Date: 17-Jul-2026  
Our Ref: 2026/91490

**Application for a non-material amendment following a grant of planning permission,  
Town and Country Planning Act 1990**

**Non material amendment to previous permission 2023/91212 for erection of 21  
dwellings with access from Laithe Avenue  
Land off, Bankfield Drive, Holmbridge, Holmfirth, HD9 2PH  
Application Number: 2026/91490**

Planning condition 23 – Materials Rev A

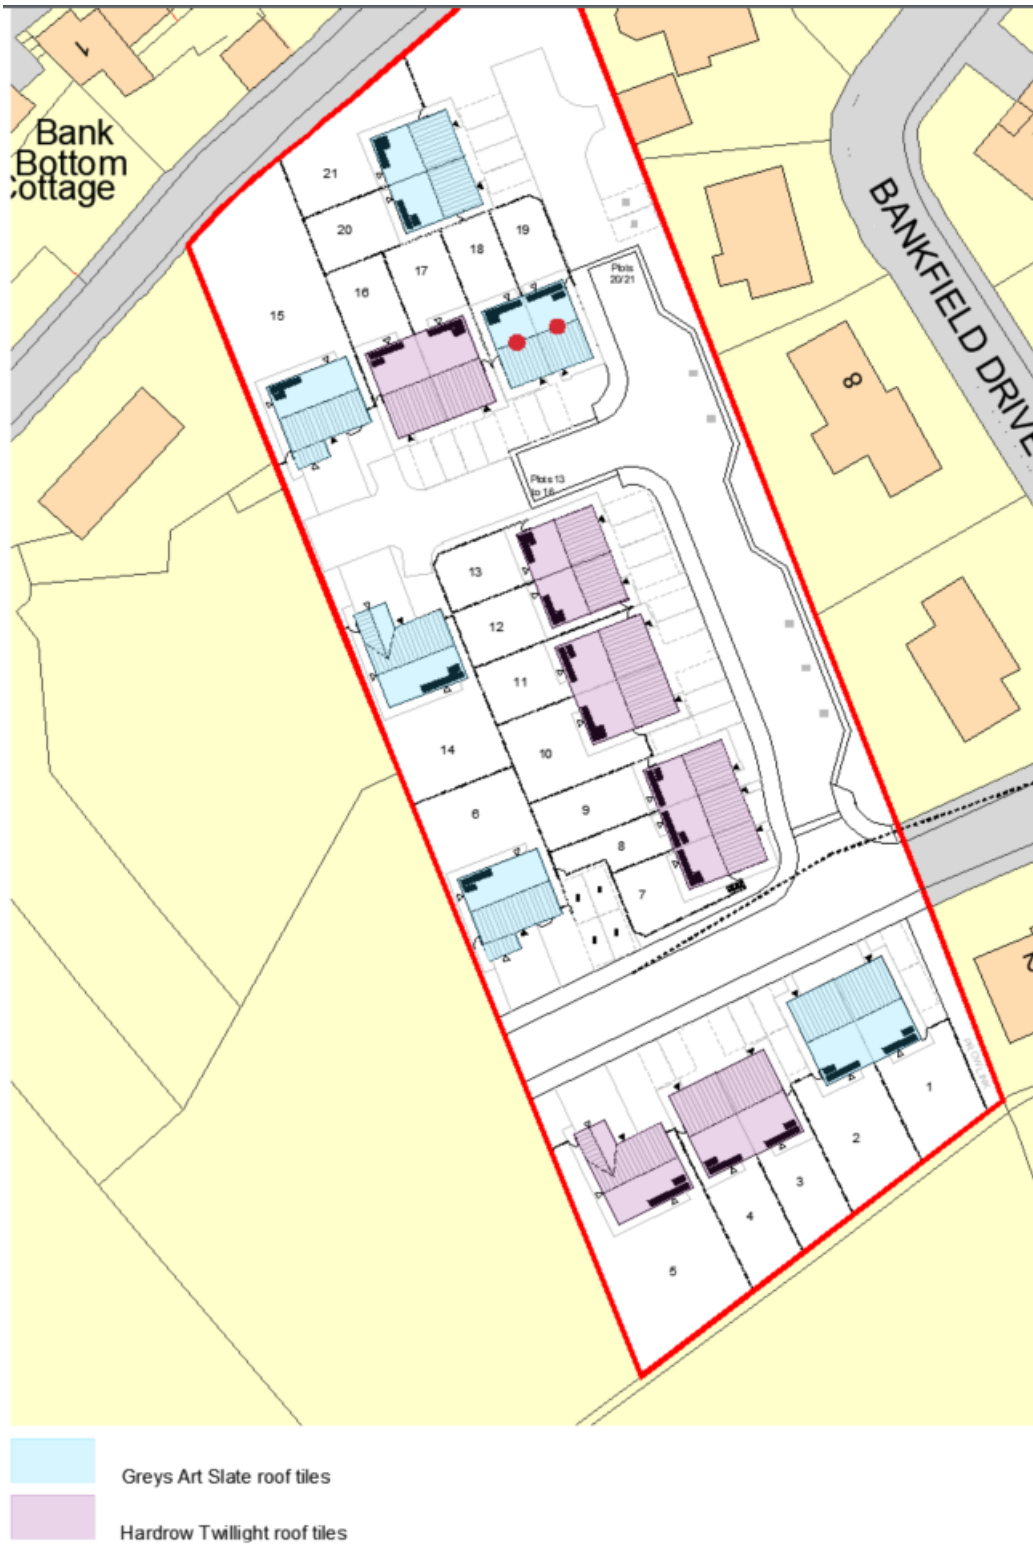
- To amend the previously approved roof tiles to include a secondary roofing material on the site due to the manufacture of the approved tiles (Hardrow Twillight roof tiles) no longer being able to produce enough supply for the full development. The new roof tile is Grays Art Slate roof tile in the Reproduction Country Weathered reclaimed slate.

I confirm that the alterations are acceptable and may be considered as a non-material amendment to the approved drawings. It should be noted that this letter relates only to the non-material amendment sought and it is not a re-issue of the original planning permission. The two documents should be read together and as such, all conditions imposed on the original granting of planning permission apply to the proposal as now amended. A copy of this letter and the amended plans will be retained on the public record of approved documents.
